Date: 01 July 2024

Application by RWE Renewables UK Dogger Bank South (West) Ltd and RWE Renewables UK Dogger Bank South (East) Ltd for an Order Granting Development Consent for the Dogger Bank South Offshore Wind Farms

Request for signposting

DRAWING TITLE
Offshore Statutory and Non-Statutory Nature Conservation Sites

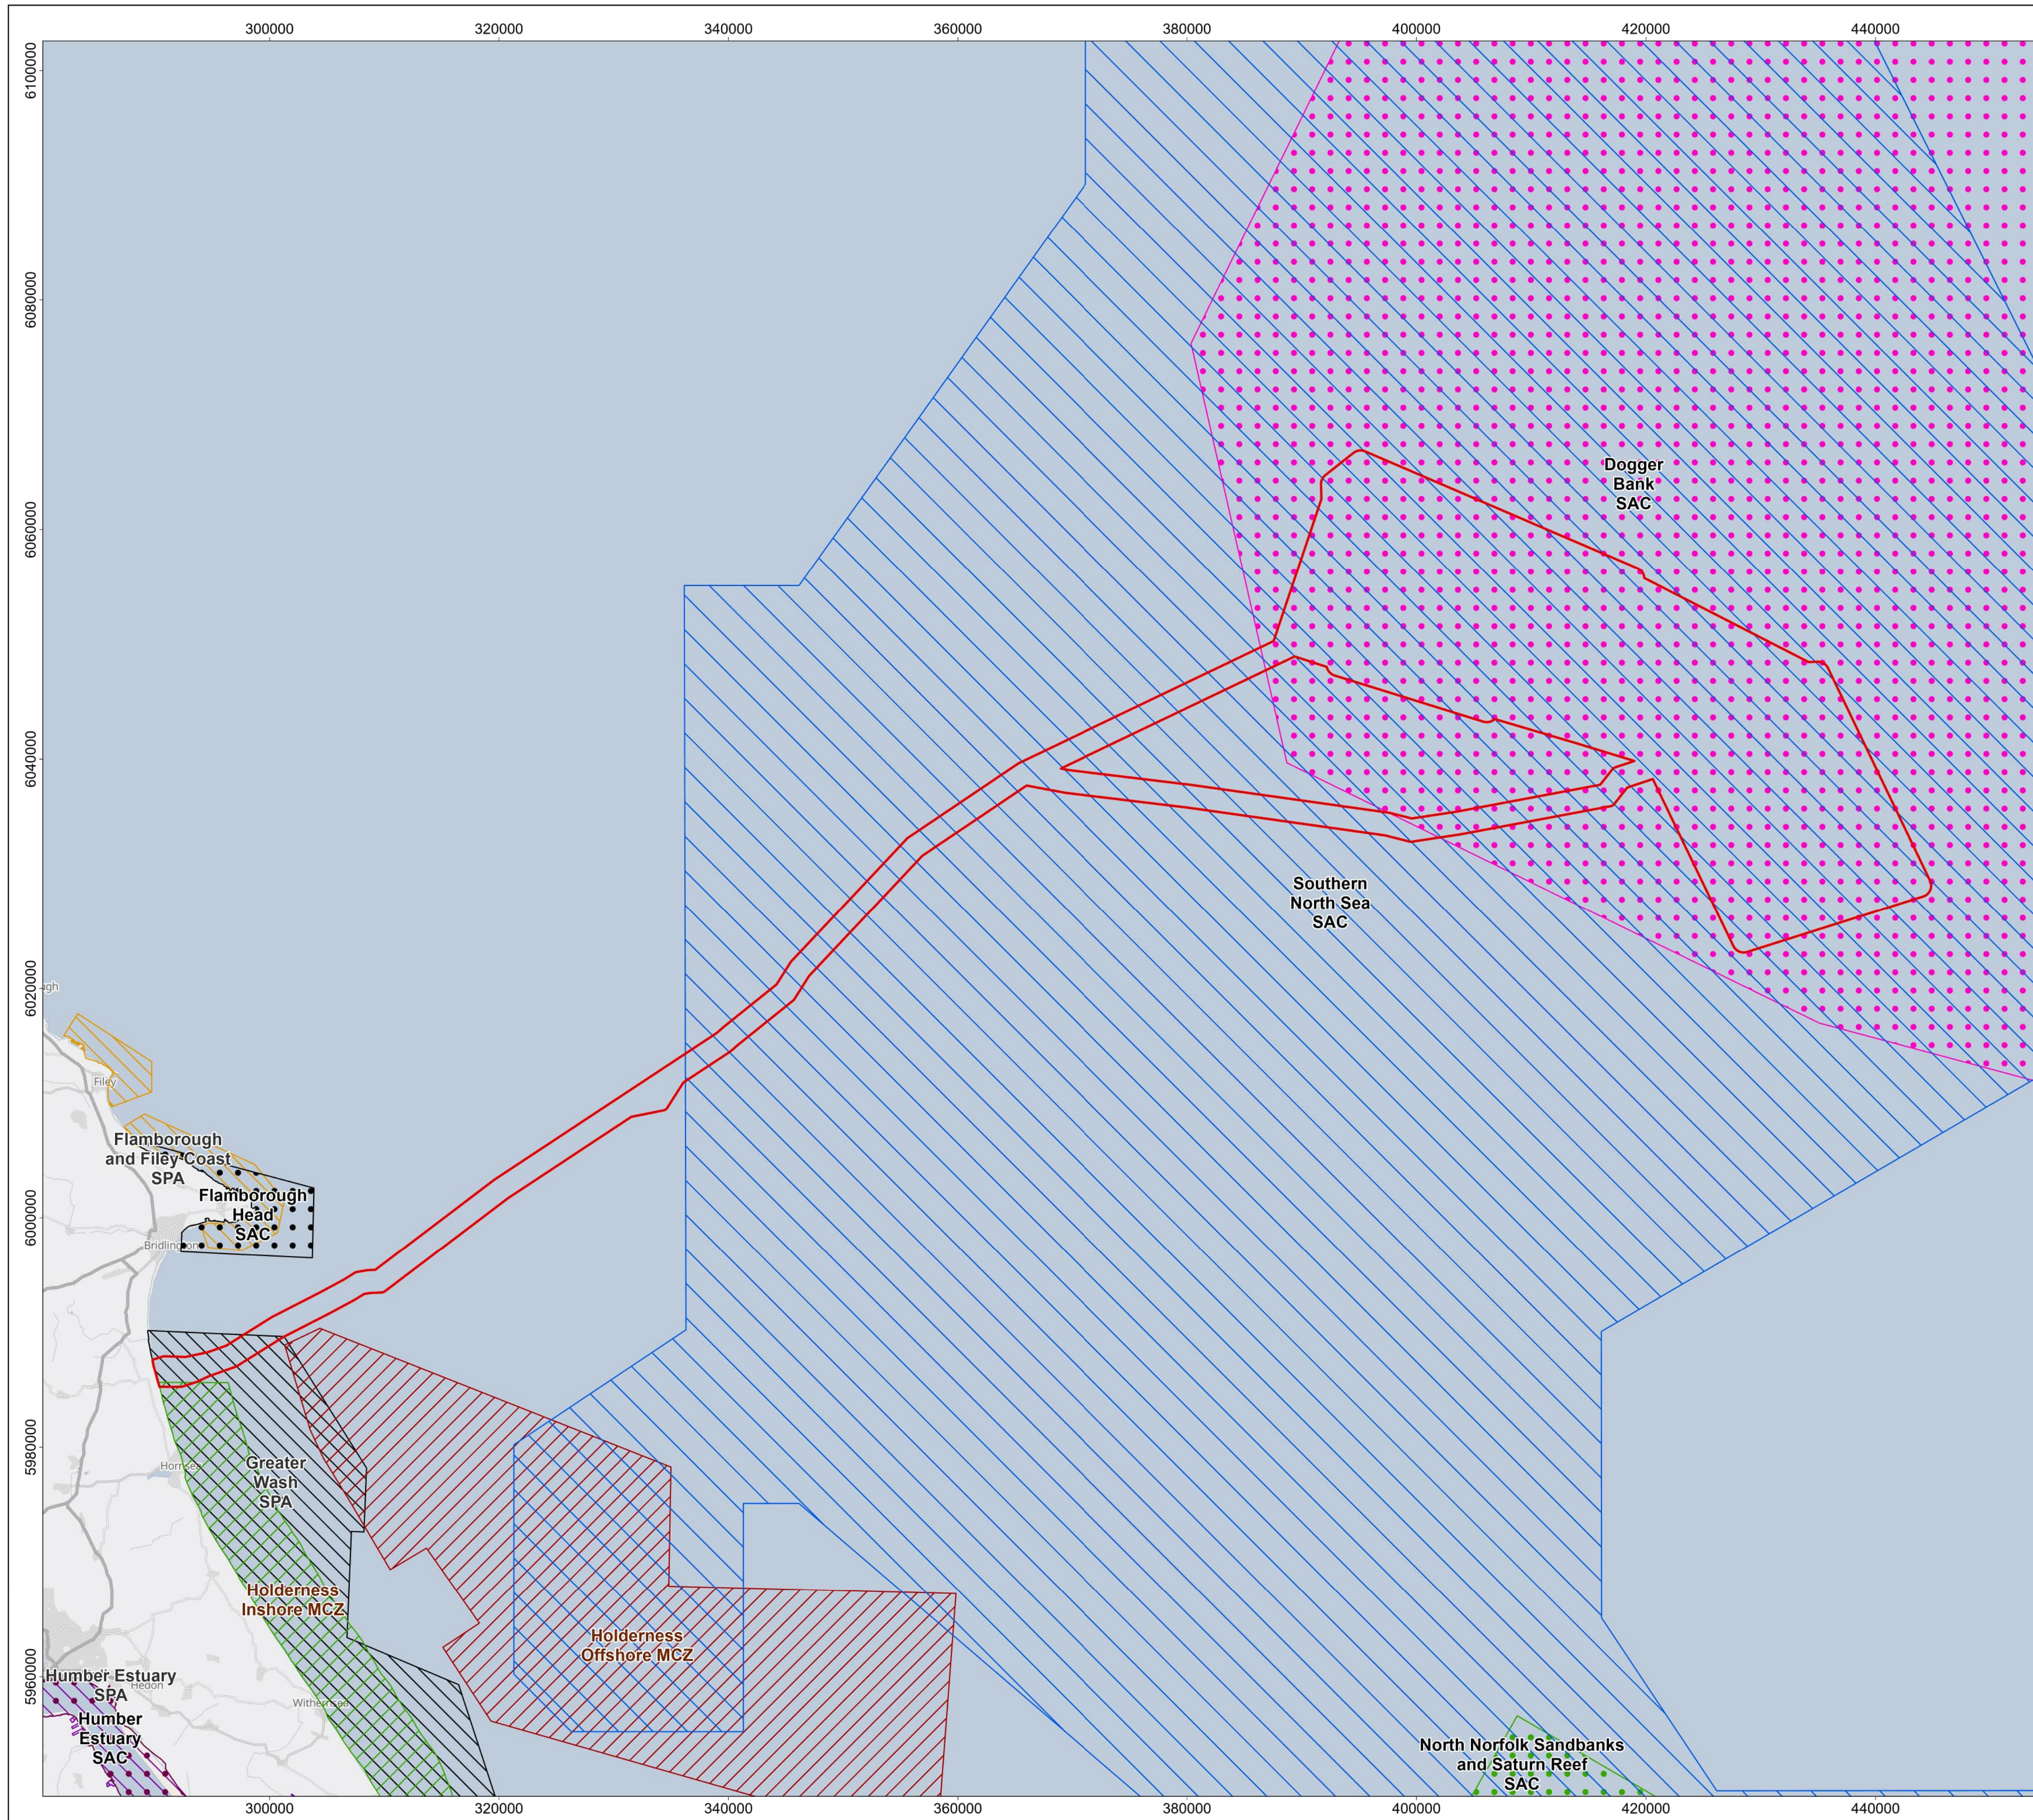
The **Offshore Statutory and Non-statutory Nature Conservation Sites Plan (Doc 2.13)** identifies the relevant sites considered in the ES (**Doc 7.12**) and RIAA (**Doc 6.1**), with the exception of Special Protection Areas (SPAs) beyond 10km from the Proposed Development (eg Farne Islands SPA or SPAs in Scotland). The Applicant is requested to signpost the Planning Inspectorate to where these SPAs have been illustrated in the application.
